Great North Road Solar and Biodiversity Park

Statement of Common Ground with Nottinghamshire Wildlife Trust

Document Reference – EN010162/APP/8.11B

February 2026

**Figure 12: Masterplan (Northeast)**

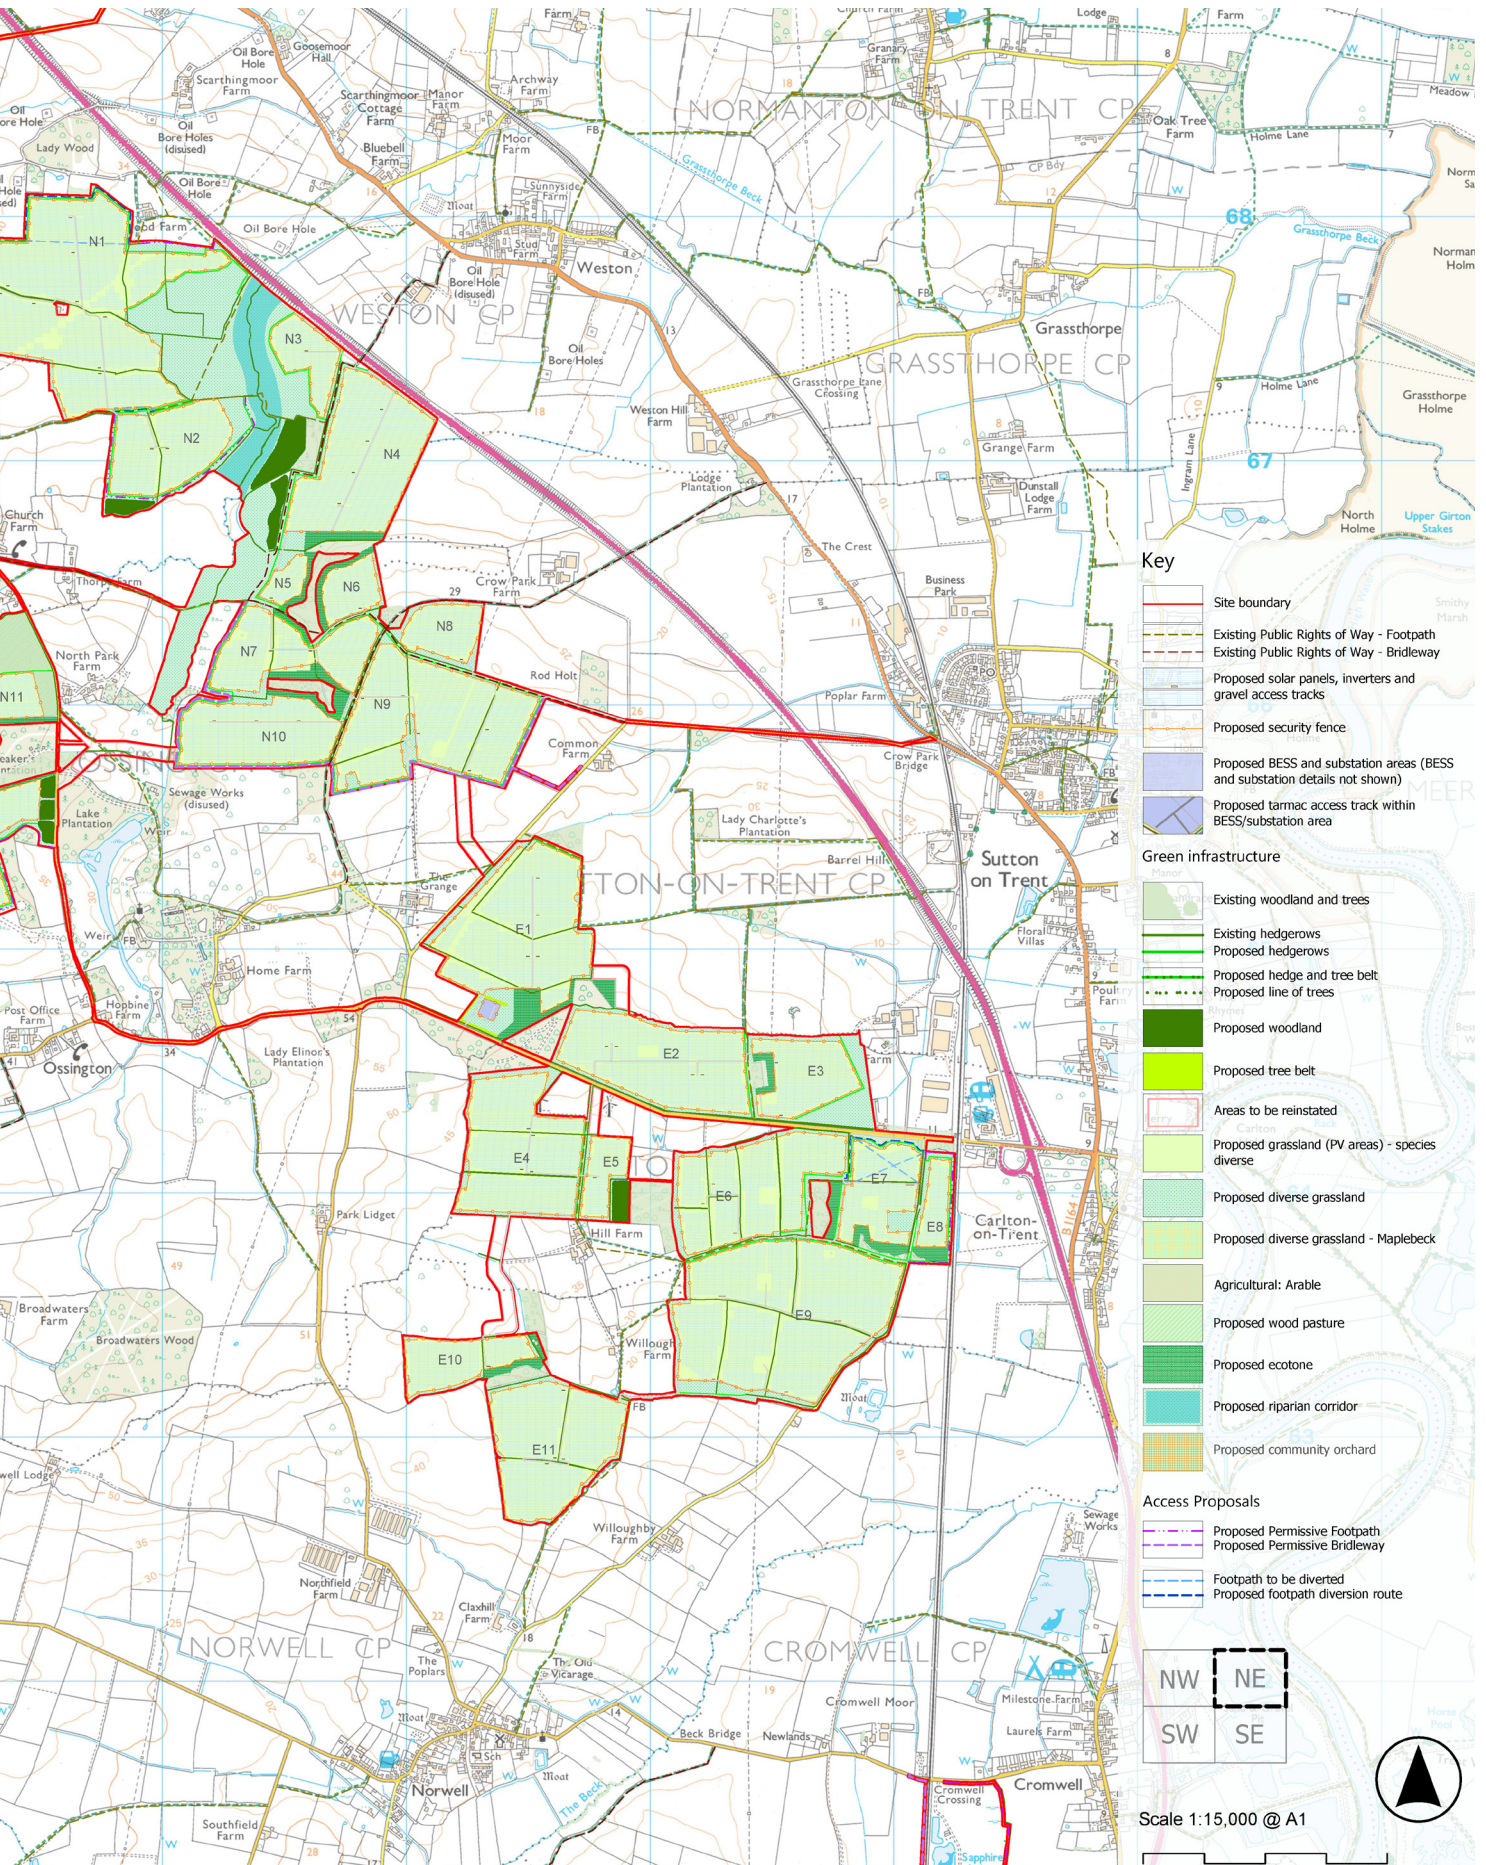
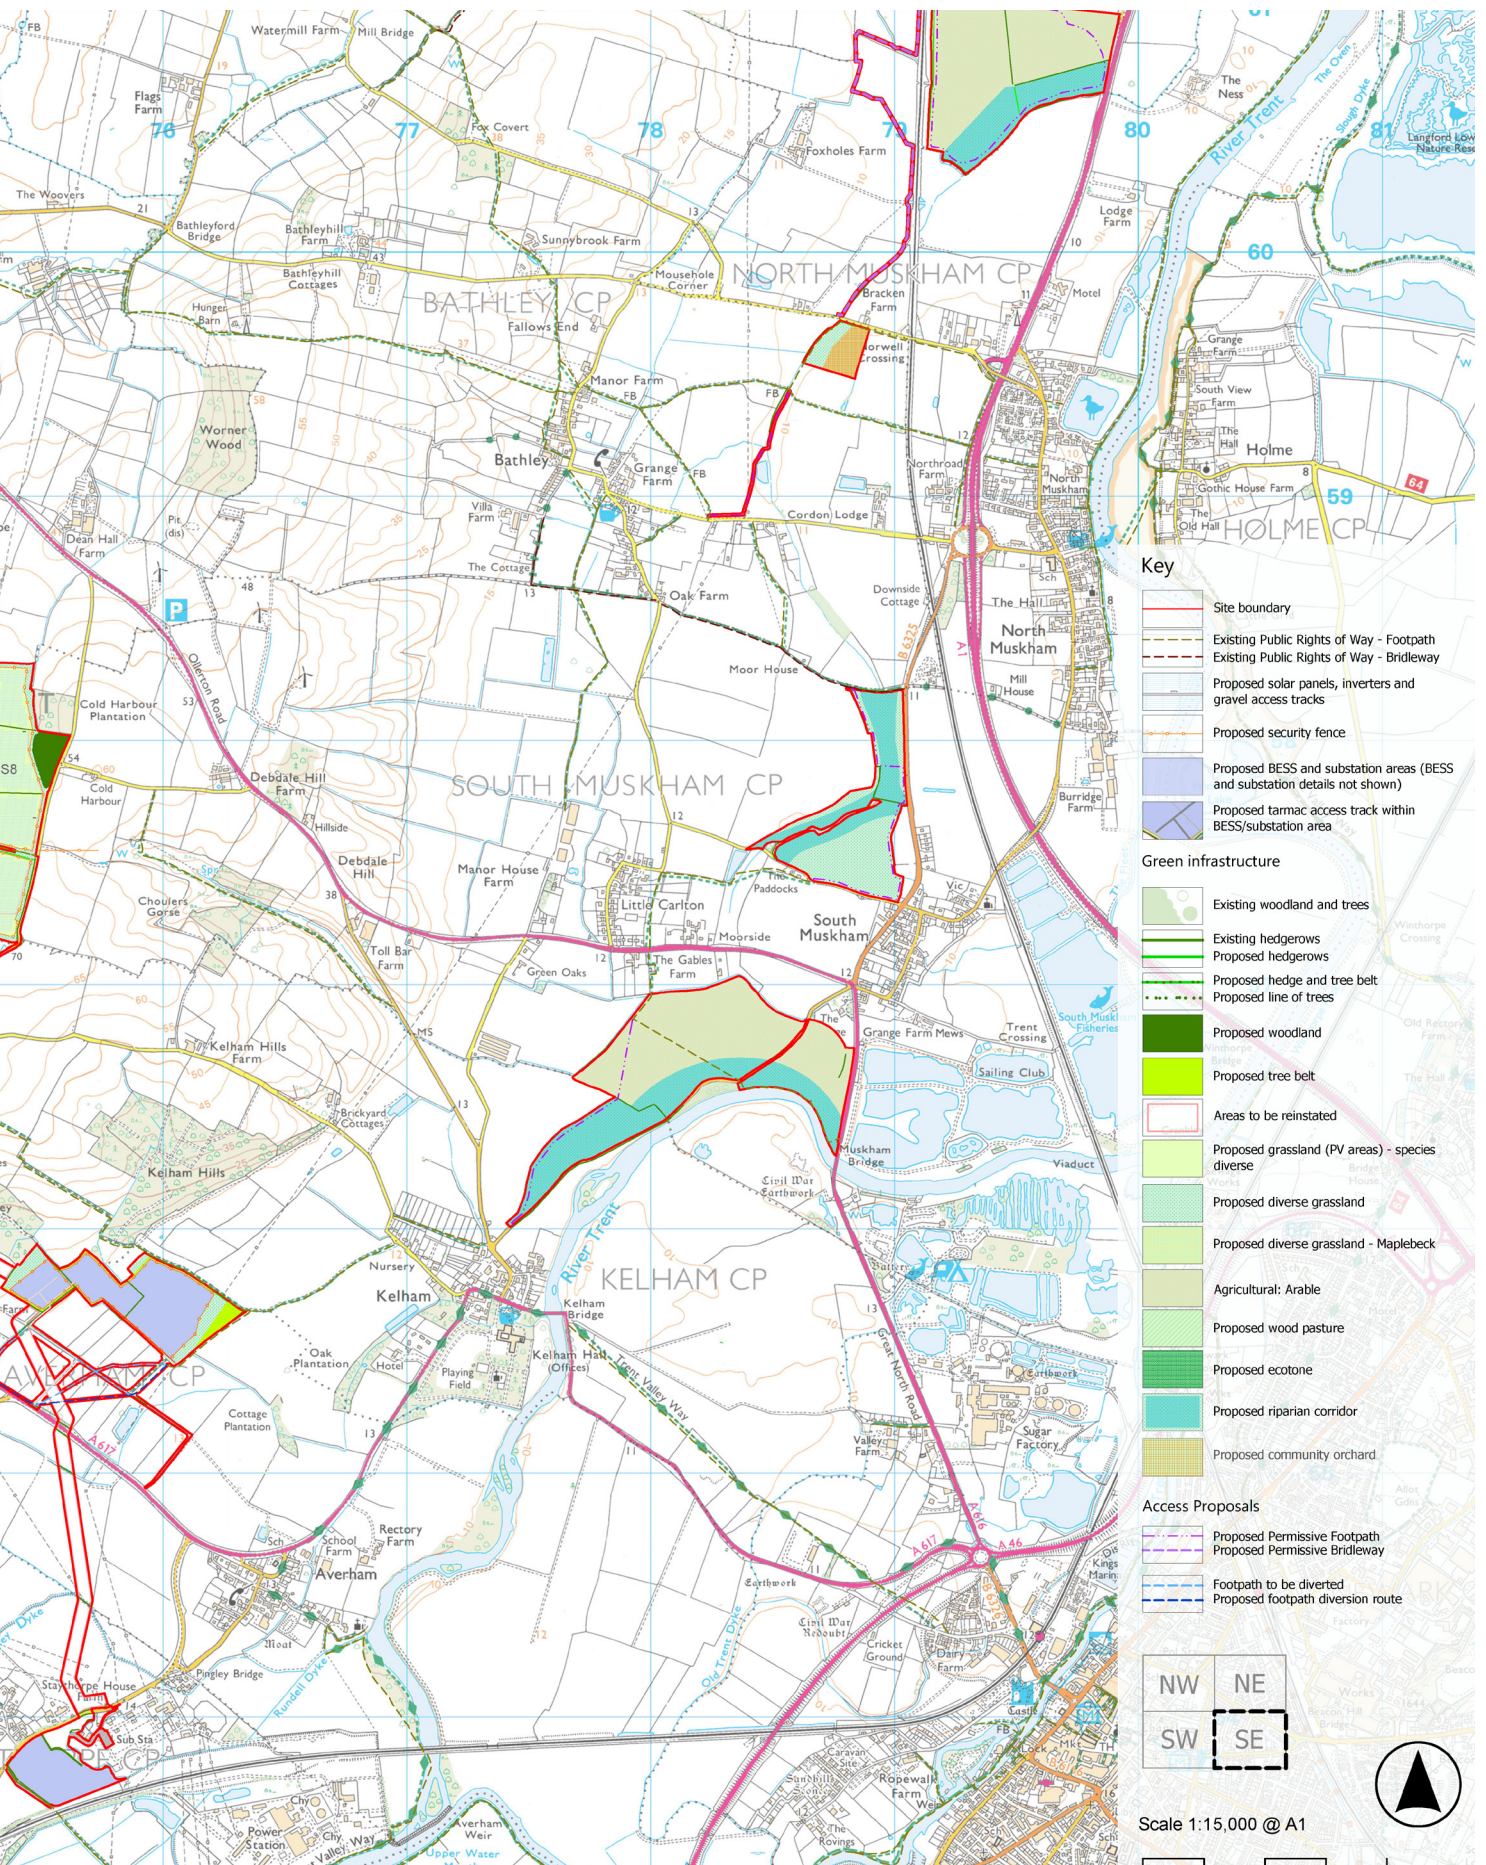
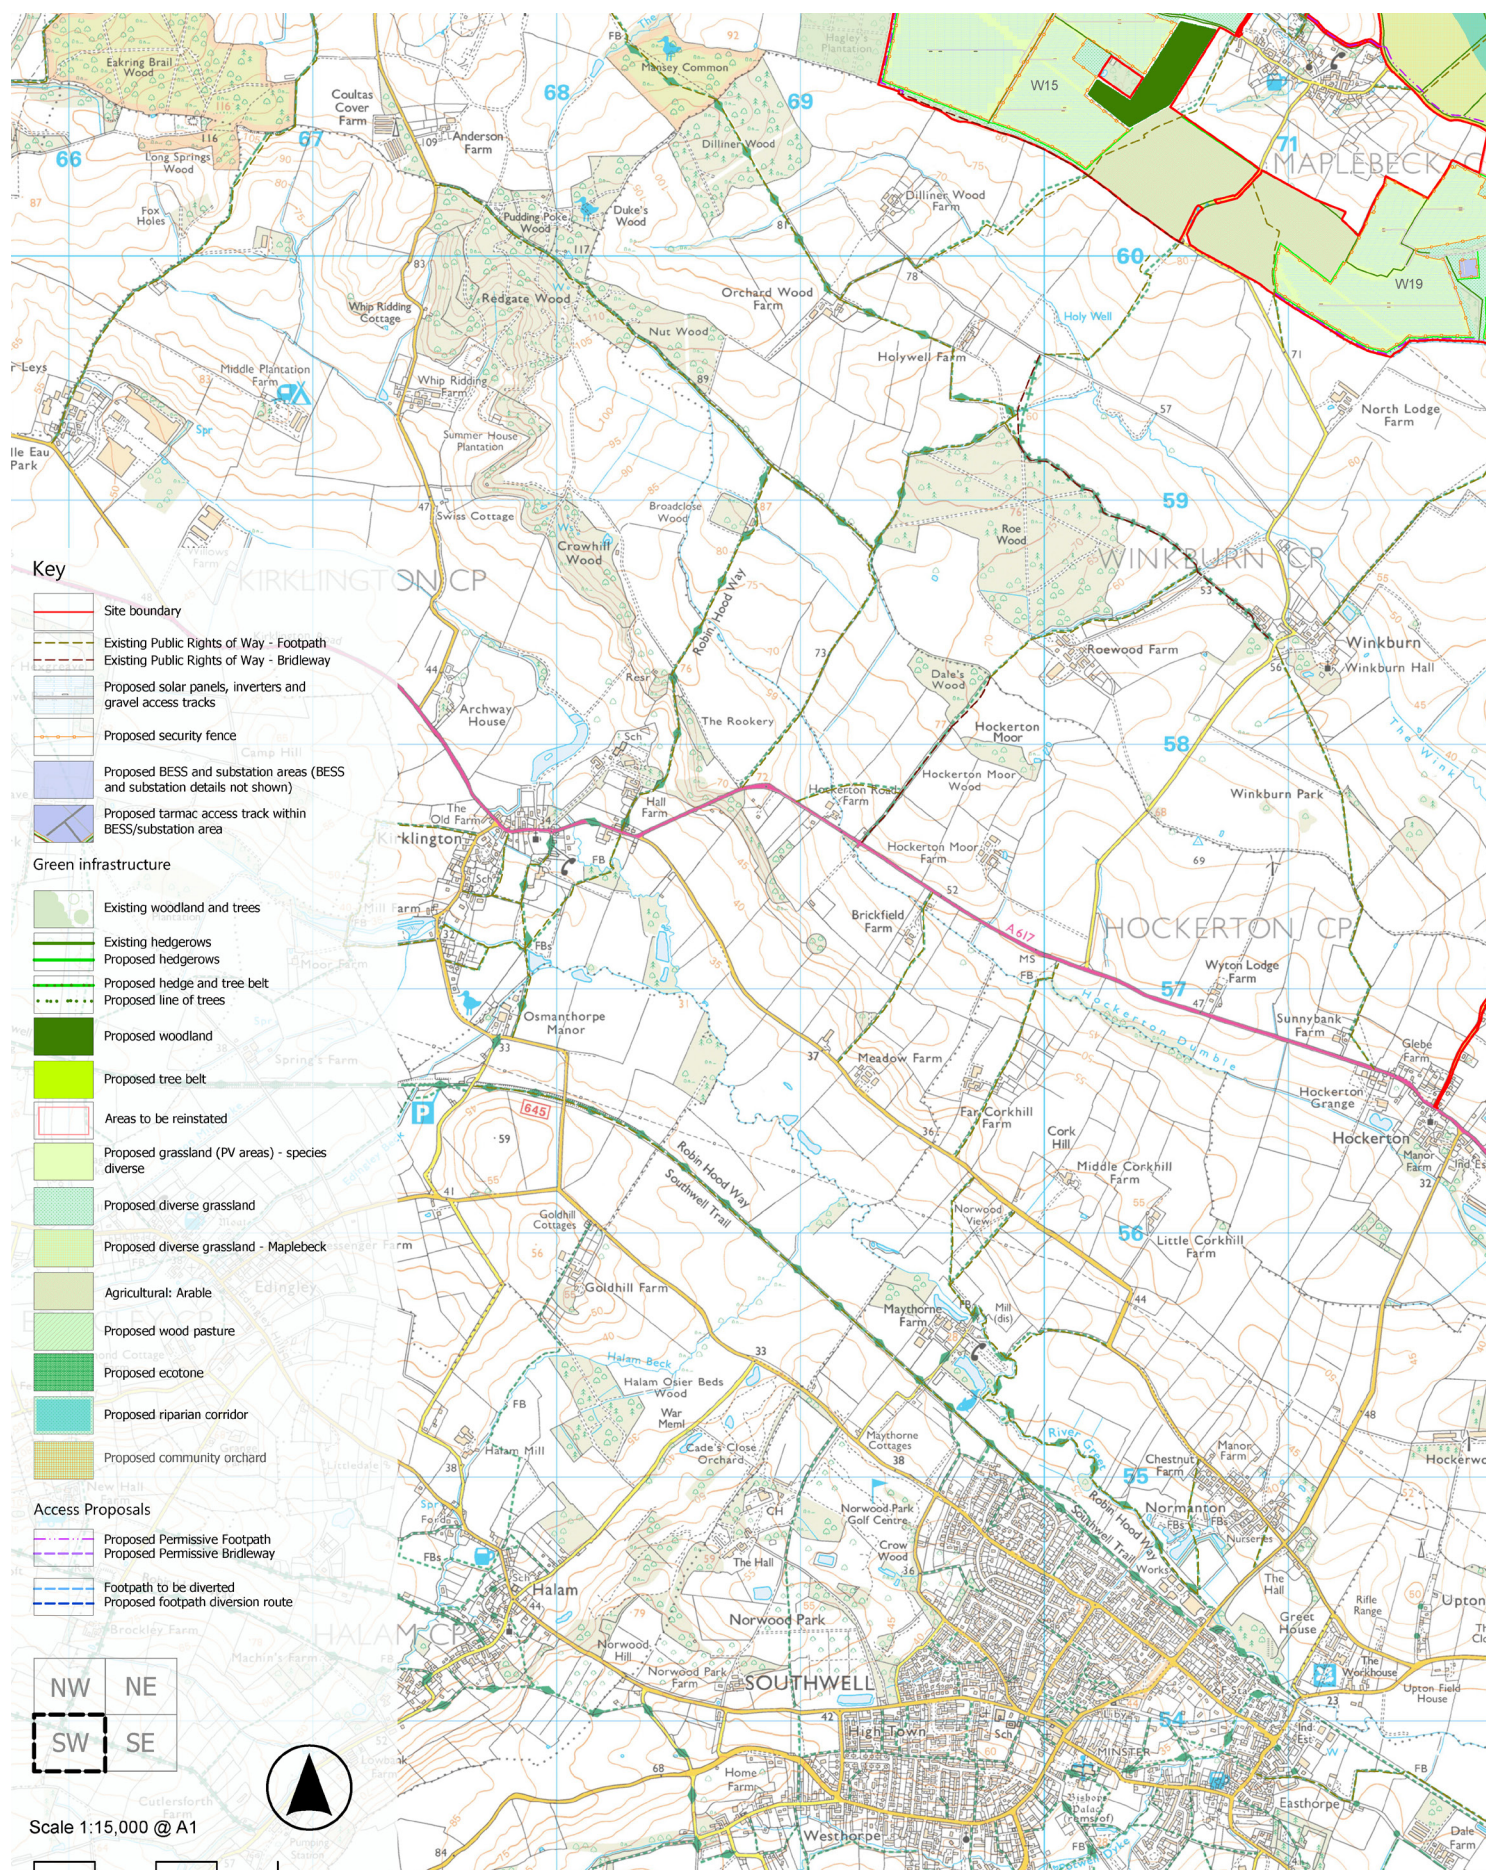
2.2.3	Meeting (27/01/2026)	Scattered tree planting	<p>Concerned that tree planting in or near open areas would discourage nesting birds such as lapwing and waders. Recommend that black poplar is included in the tree planting specification.</p>	<p>The specification of the tree planting in the riparian corridor has been revised in section 22 of Table A5.1.5 in ES Volume 4, Appendix A5.1: Outline Landscape and Ecological Management Plan (LEMP) [EN010162/APP/6.4.5.1C] to</p>	Agreed

Ref	Relevant Documents	Description Of Matter	Nottinghamshire Wildlife Trust's Position	Applicant's Position	Status
				<p>make clear that the locations of tree planting will be selected to limit their potential to discourage nesting birds. The locations shown on the Masterplan are therefore purely indicative. Black poplar has been added to the specification.</p>
